**Response to Planning application from Hertfordshire County Council (T and CP GDP Order 2015)**

**District ref:** 6/2018/0020/HOUSE  
**HCC ref:** WH/33/2018  
**HCC received:** 31/01/2018  
**Area manager:** Manjinder Sehmi  
**Case officer:** Anthony Collier

**Location**  
16 Daffodil Close  
Hatfield  
AL10 9FF

**Proposal**  
Erection of a two storey rear extension and conversion of garage into a habitable room

PROPOSED GROUND FLOOR PLAN

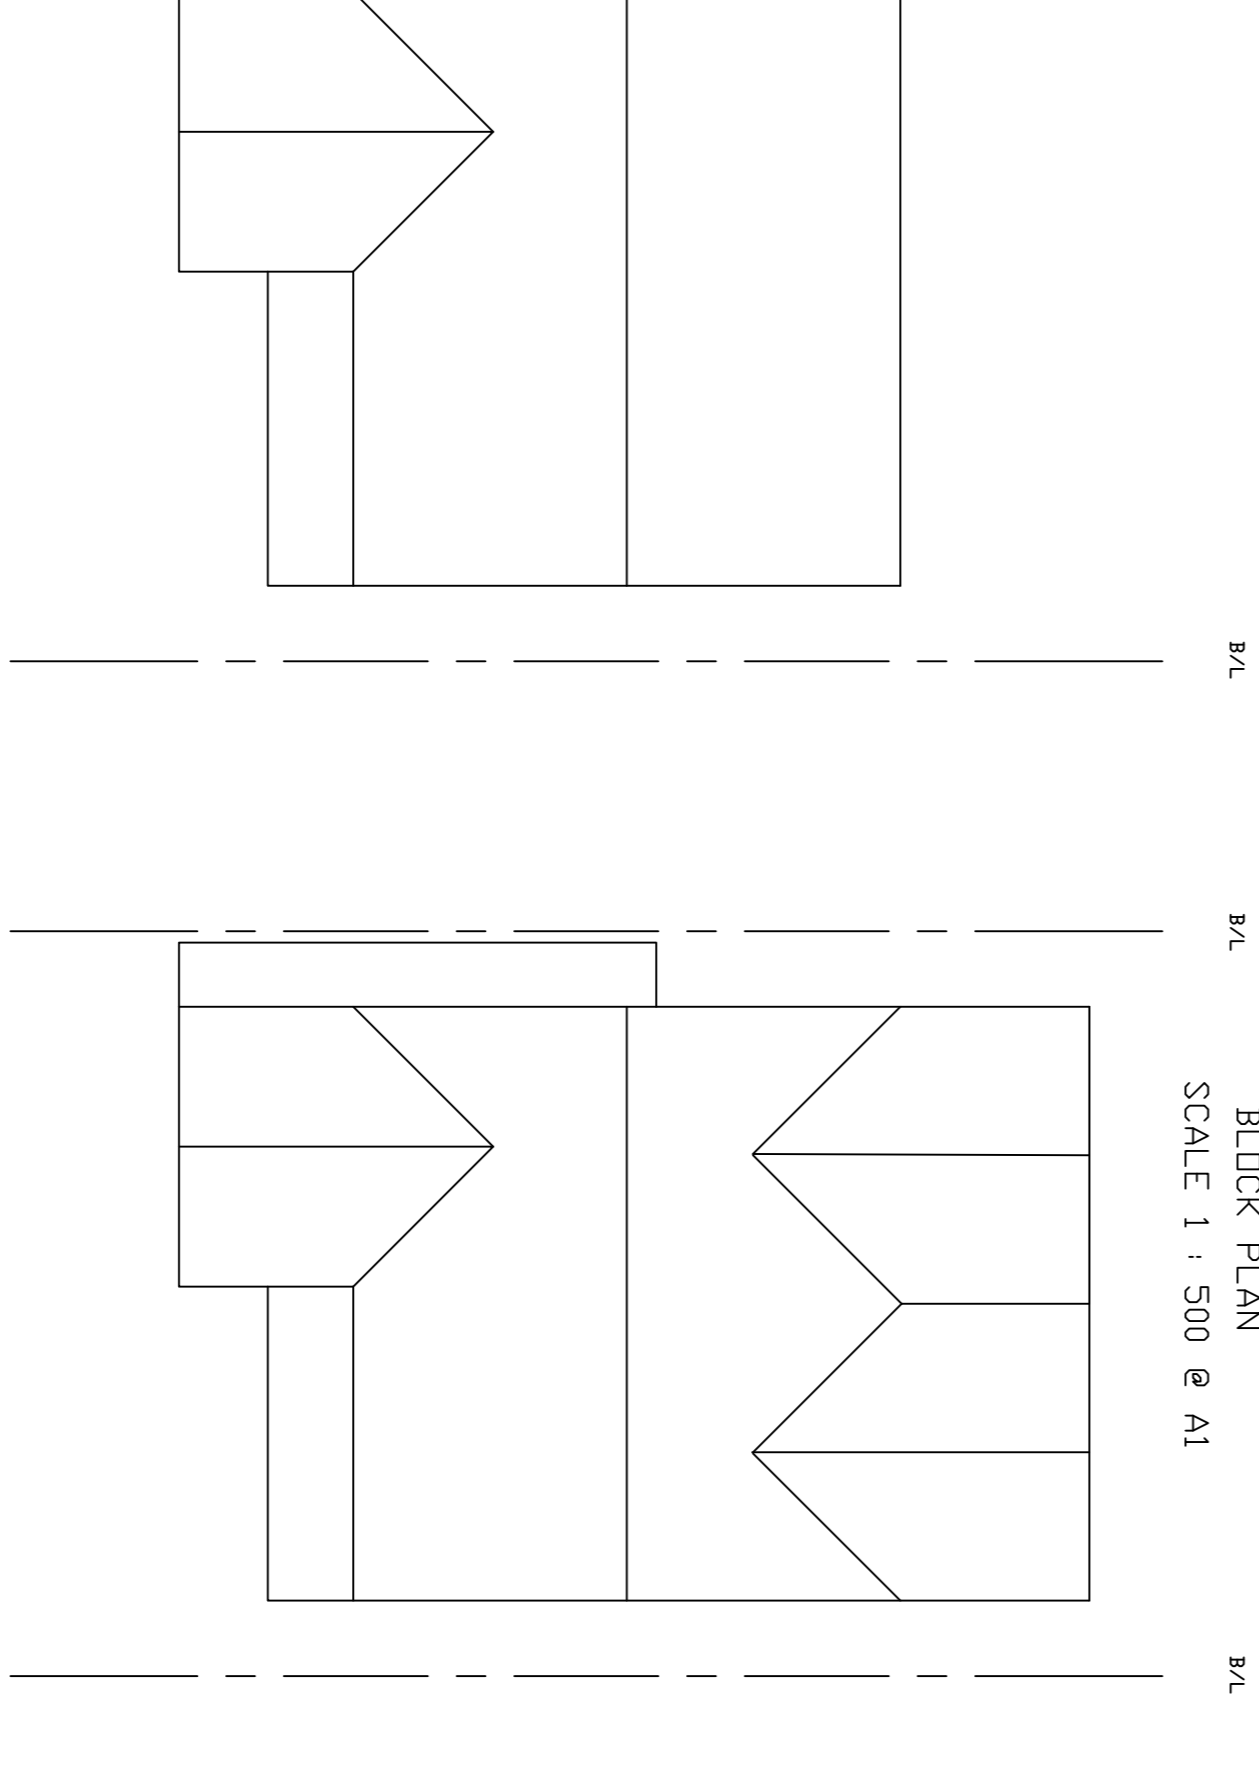
The removal of the garage if it was suitable for vehicle parking leaves provision for two vehicles on the dwellings driveway suitable for its use.

No aspect of the design prevent the use of sustainable transport, with storage for bicycles still remaining within the site despite the removal of the garage.
